**RFI**

RFI #: 61  
Date: 2/22/2012  
Job: EB-02 Keller Springs Lofts  
Phone: 877-777-5115

Subject: Fire Extinguisher Cabinets Locations

Drawing: 3.1A, 3.2A, 3.3A, 3.4A, 3.4F  
Cost Impact: None

SHEET NUMBER
3.2A
BLDG PLAN 'A'

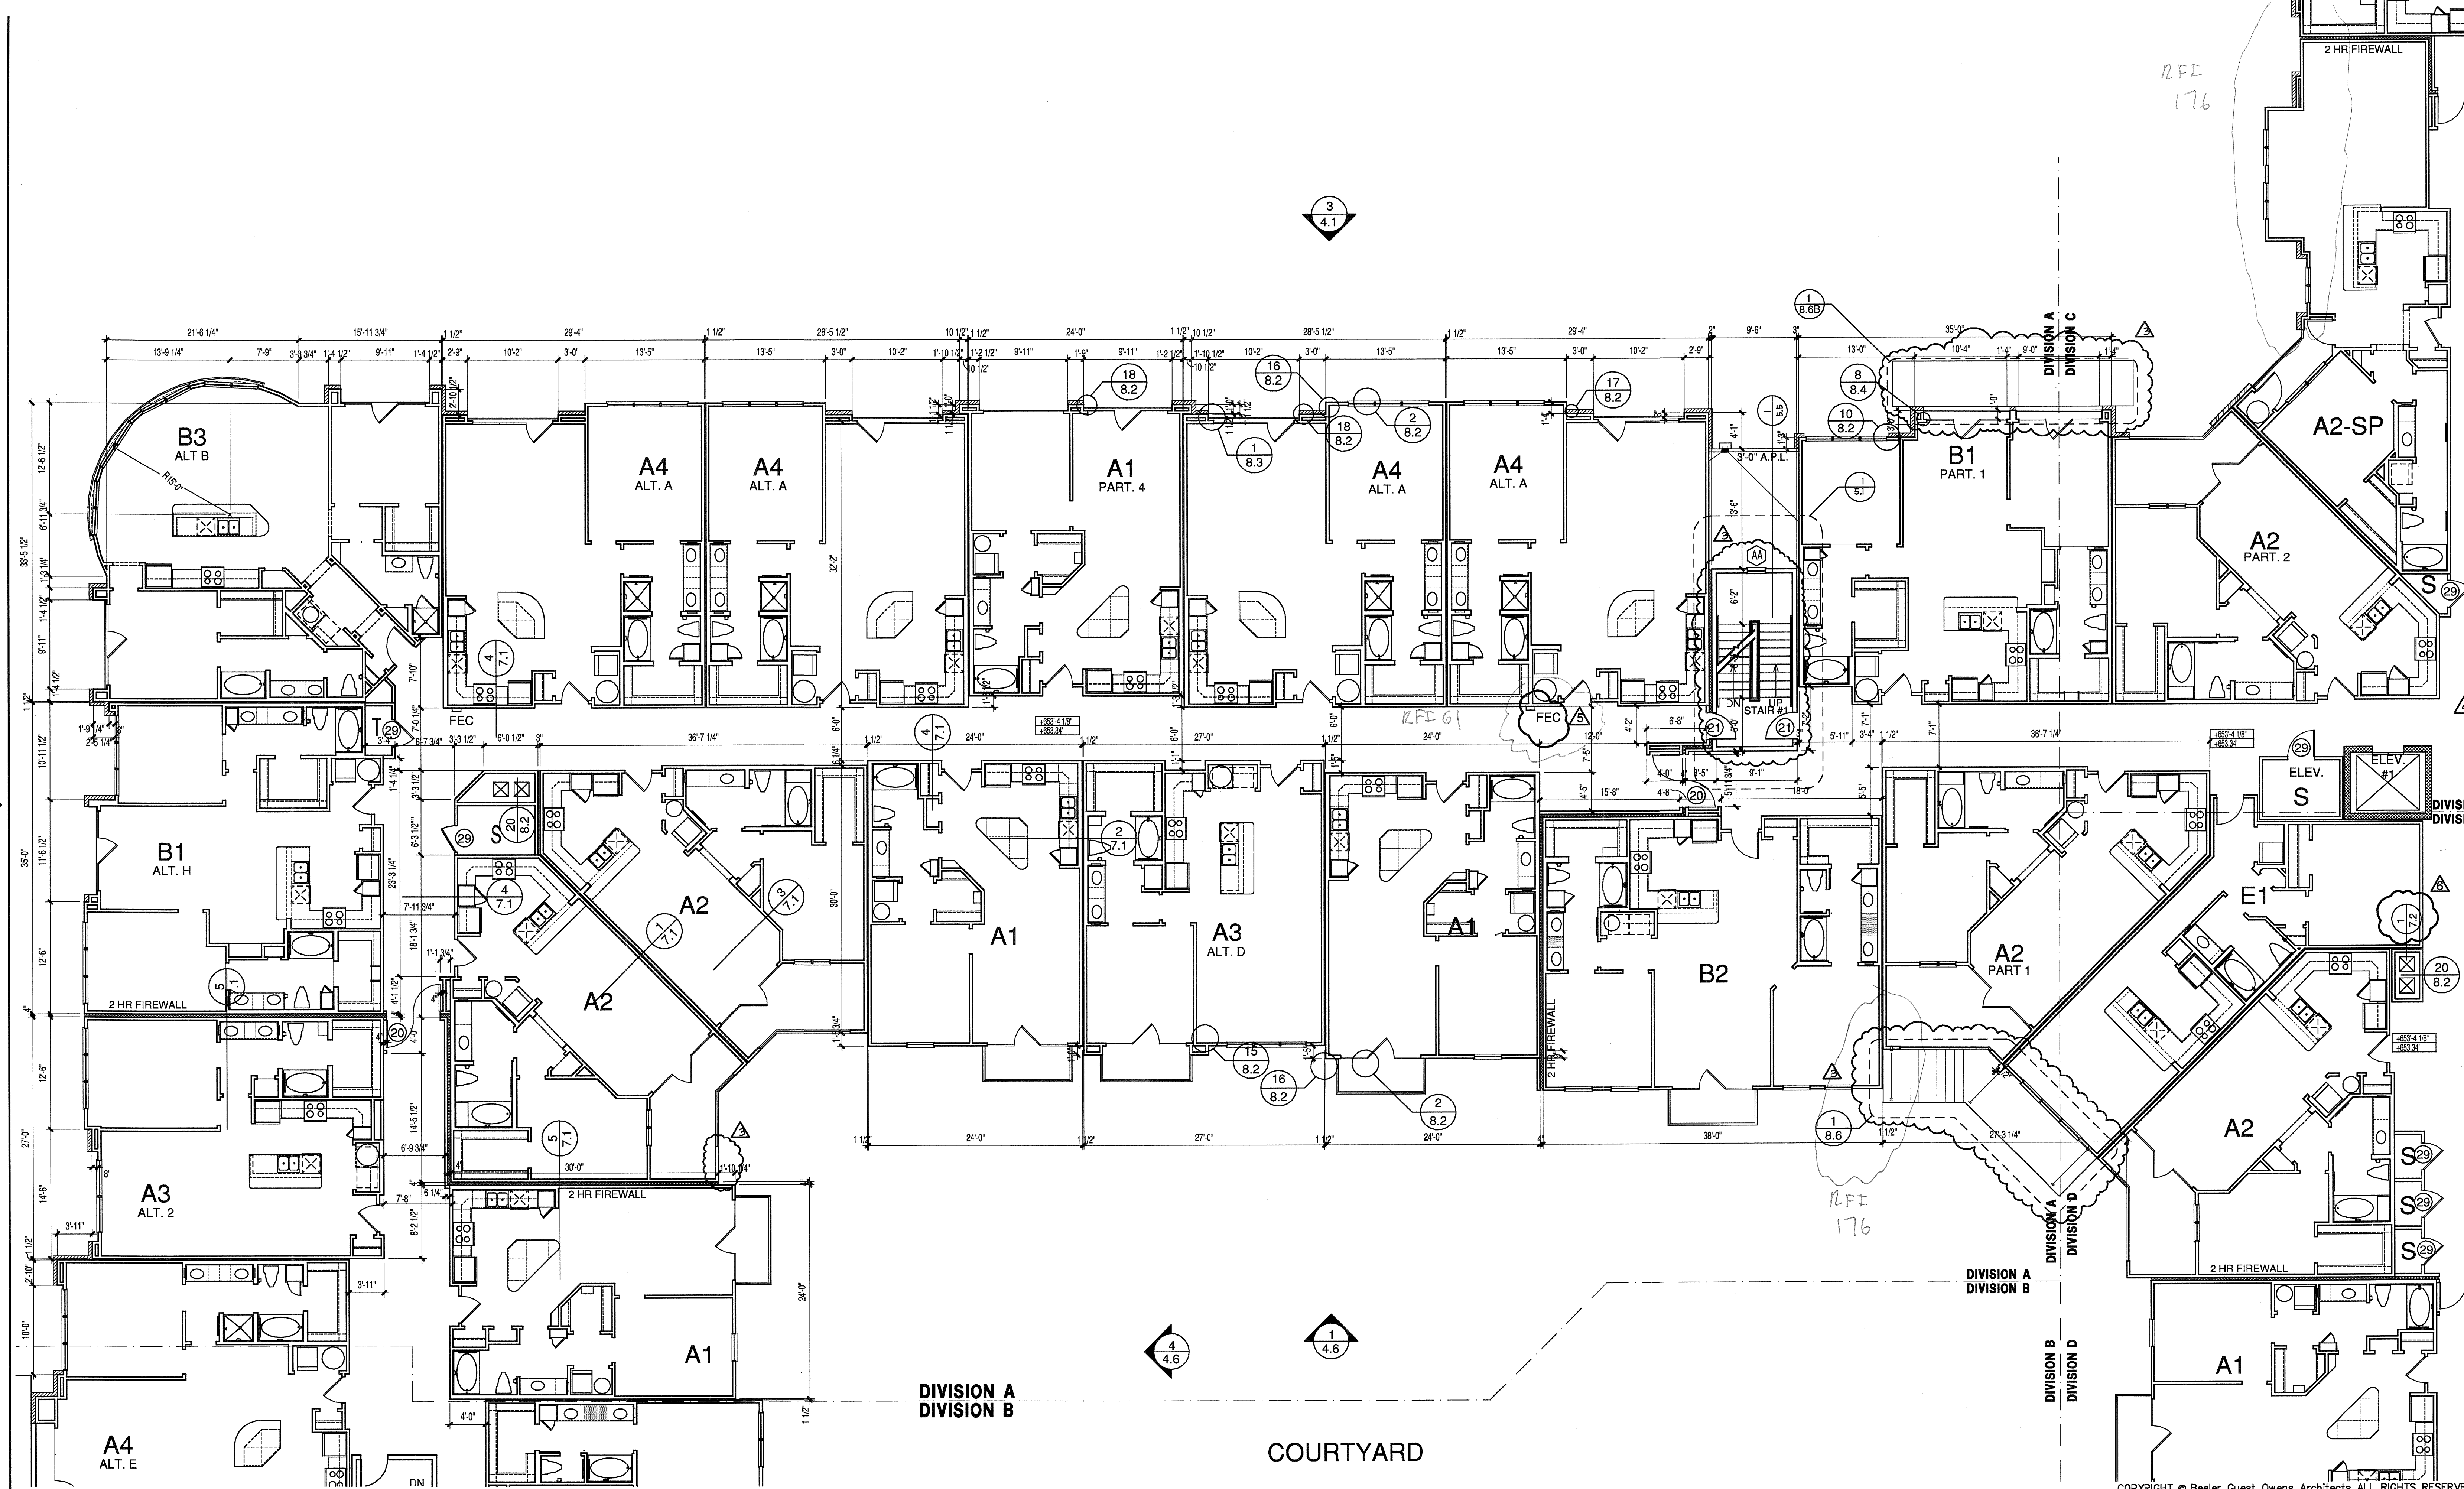
**Request:** Date Required: 2/29/2012  
1) There are some inconsistency's with plans for FEC locations in corridors.  
3.1A shows 2 FEC  
3.2A shows 1 FEC  
3.3A shows 1 FEC  
3.4A shows 2 FEC  
Do you want 2nd FEC added for 2nd & 3rd floors?  
2) On sheet 3.4F - FEC mark is missing on A4 Alt G wall.  
The FEC is shown on 1st, 2nd and 3rd floors, does the FEC need to be included at 4th floor?  
Please verify all sections for coordination and consistency.  
3) Do we need fire extinguishers in club/leasing? We have assumed 1 for club and 1 for leasing.  
4) Do we need FE in parking garage and if so what type of mounting?  
**Requested by:** Bryan Pickler  
Embrey Partners, Ltd.

**Response:**  
1- Yes.  
2- Yes. I've checked all locations and the one's you mentioned are the only problem locations. I adjusted 2 other FEC locations by moving them a foot or so now all FECs line up in the same spot from floor to floor (except for the Club and Garage areas).  
3- I've placed the 2 FECs you mentioned in sheet 9.1  
4- Yes, we need them in the parking garage. I've updated the sheets to reflect this. Double check with your local Fire Marshall, but I'm confident that a surface mounting will be fine.
